Subject: RE: Notification of Modification Request for Four Points by Sheraton Hotel Expansion (SSD 4972 MOD 7)
Date: Wednesday, 18 September 2019 at 5:23:07 pm Australian Eastern Standard Time
From: George Mobayed
To: Jenny Watt
CC: Lisa McGill, Mark Pepper, Lawren.Drummond@planning.nsw.gov.au
Attachments: image005.jpg, image006.jpg, image002.jpg, TfNSW Response to Notification of Modification Request for Four Points b....pdf, Modification Application - Additional Information Letter - 4.2.19.pdf, Attachment F1_4.2.19_ZC-DA-16-20_02 Wheat Road Layout Plan.pdf, Attachment G_4.2.19_TTW Wheat Road Traffic Safety Review.pdf

As part of the Response to Submissions, the applicant should consider the following:

Drawing Title
WHEAT ROAD
BUS BAY TURNING PATHS
1 OF 2

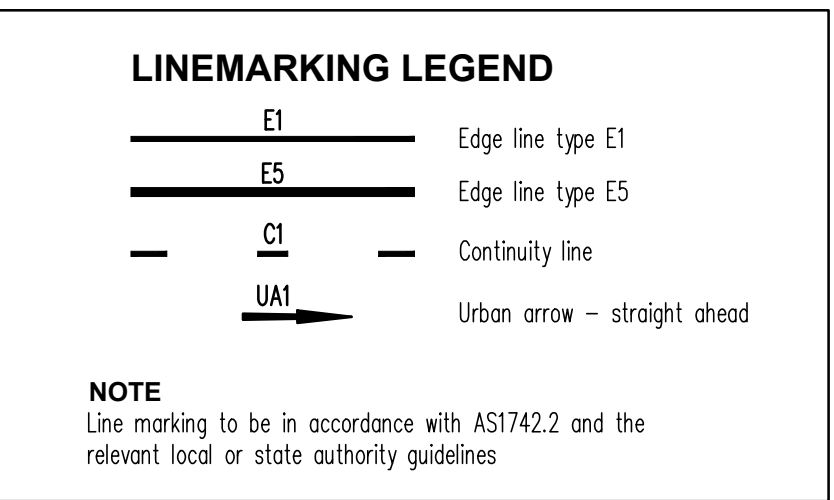
- Vehicle swept path diagrams showing that buses could safely use the coach spaces and vehicles use the adjacent vehicle spaces; and
- Confirmation if a 14.5 metre non-rear steer bus could be accommodated, and if not, the largest size bus that could.

Thanks for meeting with Lisa and I on Tuesday to discuss the Wheat Road coach facility. Would it be possible to send through the plans reviewed by RMS? We would like to see the bus swept paths and which vehicle type was used.
